SG/GK
14274
20 December 2016

**S96(1A) - MODIFICATION APPLICATION - SSD 14_6673 – MOD 2
BLOCK 4N, CENTRAL PARK**

On behalf of Central Park JV No 2, we hereby submit an application pursuant to section 96(1A) of the *Environmental Planning and Assessment Act, 1979* (EP&A Act) to modify State Significant Development Application SSD 14_6673 relating to Block 4N, Central Park.

Revised Block 4N CENTRAL PARK – Public Domain Plan
(PA-A4-1600 – Rev. 02)
ARCHITECTURAL DESIGN STATEMENT

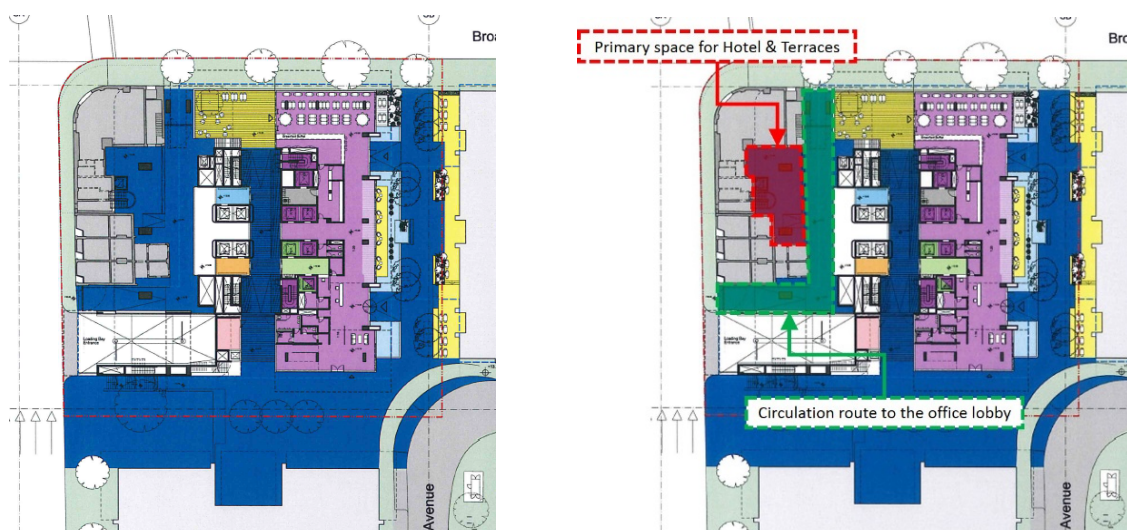
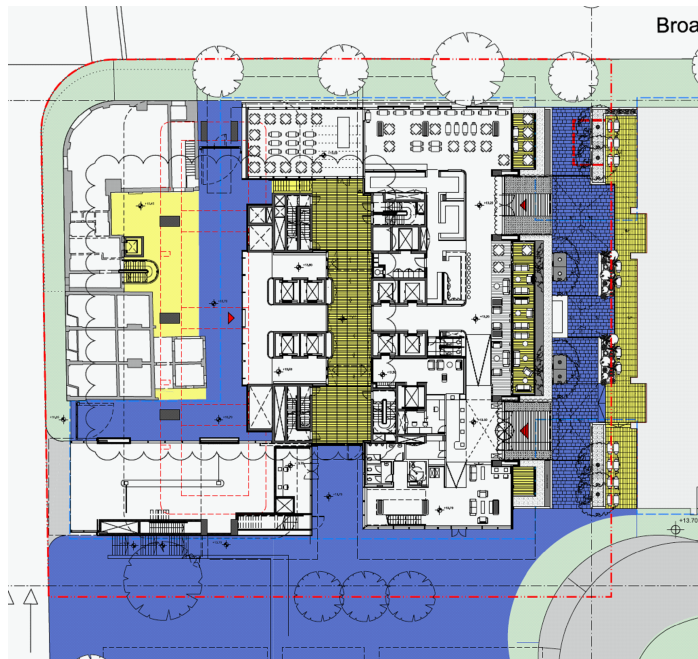
The modifications proposed in this application seek to clarify the planned use of the heritage courtyards, located behind the Australian Hotel. The modification only seeks to amend the public domain plans (as part of the Block 4N SSD), with no physical modification proposed. A Design Statement has also been provided by the Project Architects, Foster + Partners, to clarify the intended use of the heritage courtyard.

The Heritage Courtyard (as shown in **Figure 1**) has always been intended to be comprised of two distinct uses; as a primary space at the rear hotel & terraces for retail, and as the main thoroughfare and circulation route to the office lobby. This delineation of use was referenced in the Foster + Partners Architectural Design Report along with the Urbis Heritage Interpretation Plan for the Block 4N SSD. However, the clarification of this courtyard use was not accurately reflected on the public domain plan (drawing PA-A4-1600 – Public Domain Plan).

As shown in the figure produced by Foster + Partners (**Attachment B**), the modification seeks to clarify the use of the Heritage Courtyard, showing the primary space at the rear of the Australian Hotel and terraces as zone of exclusive use by tenants whilst maintaining the publicly accessible thoroughway for the circulation route, providing access to the office lobby.

Architectural (or Design) Drawings prepared by Foster + Partners			
Drawing No.	Rev	Name of Plan	Date
(Delete existing plans and replace with plans provided at Attachment A and D) - Specifically Drawing PA-A4-1600- Public Domain Plan Drawing PA-A1-1752 – Basement Level 2

BASEMENT LEVEL 2

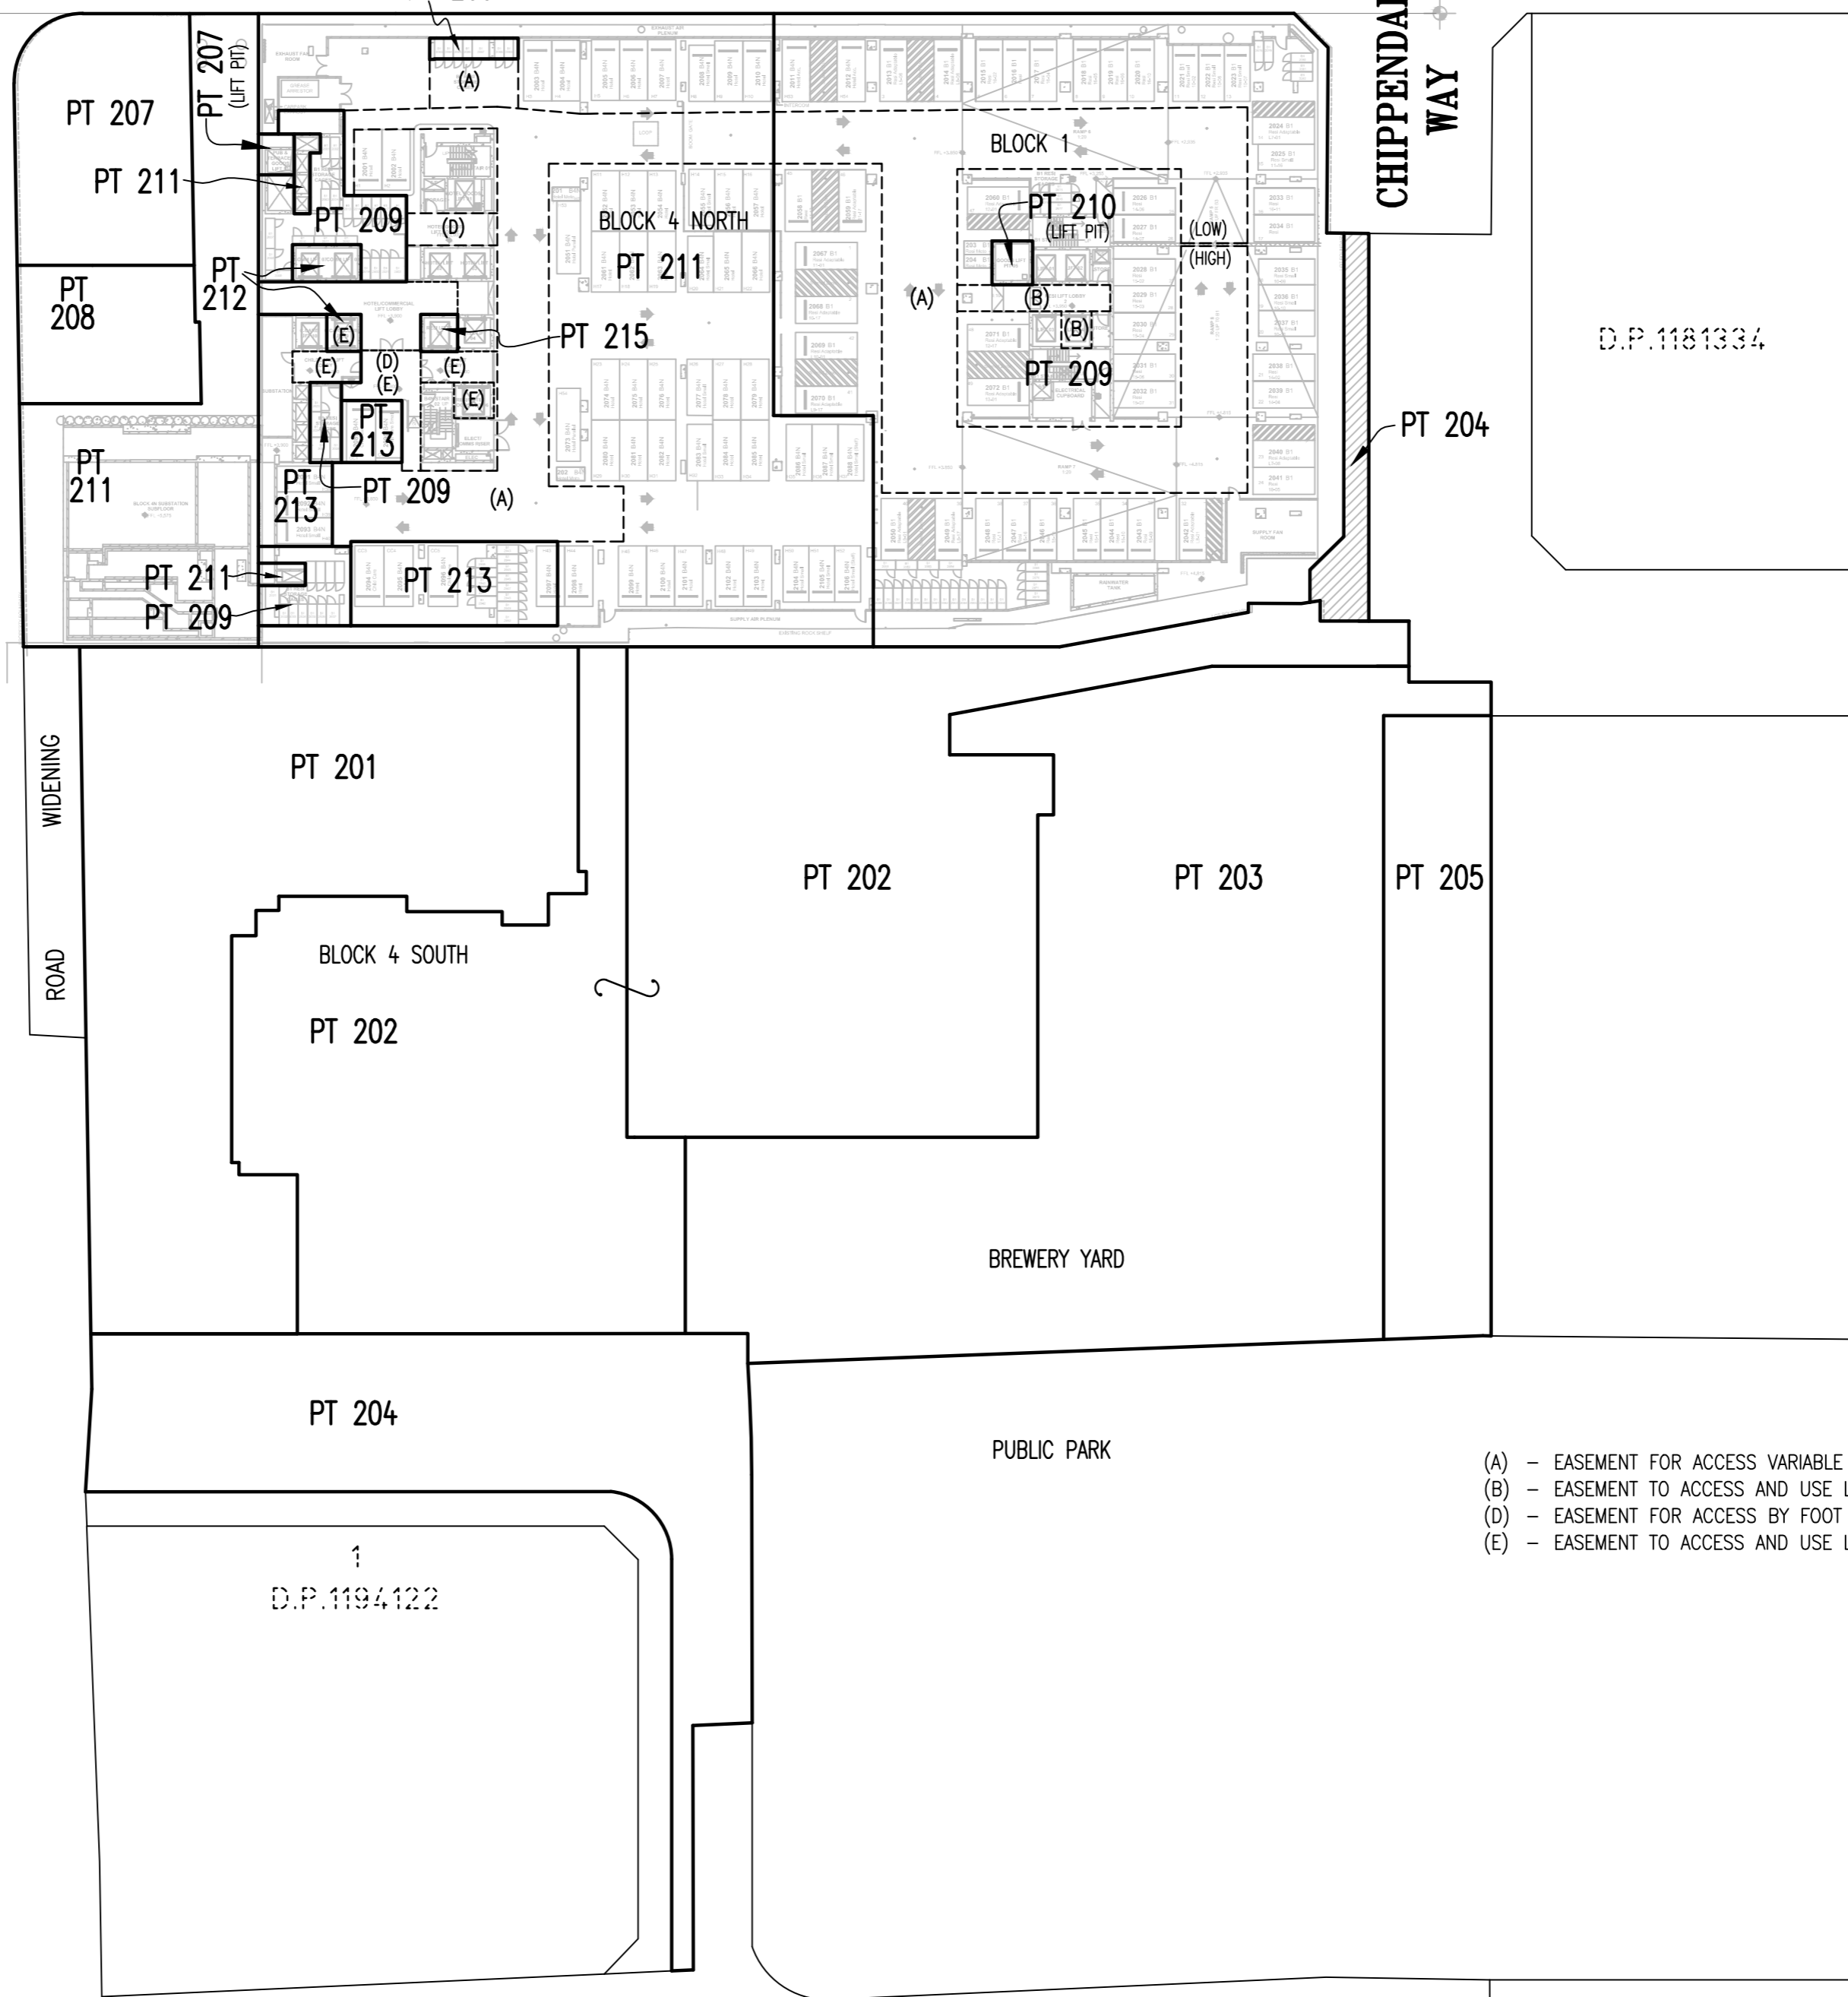
The proposal seeks to reallocate four hotel spaces to childcare spaces, located on basement Level 2. This modification amends the total childcare spaces to nine (from five) and hotel space to 50 (from 54). Refer to **Section 5.3** for further assessment

1. A total of 121 onsite car parking spaces, comprising:
 - a) ~~54~~ **50** hotel spaces
 - b) 34 residential car parking spaces (including seven accessible spaces);
 - c) 23 commercial tenant spaces;
 - d) five retail spaces; and
2. ~~five~~ **nine** childcare facility spaces.
3. Six on-site service vehicle spaces; and
4. Six on-street short term parking spaces.
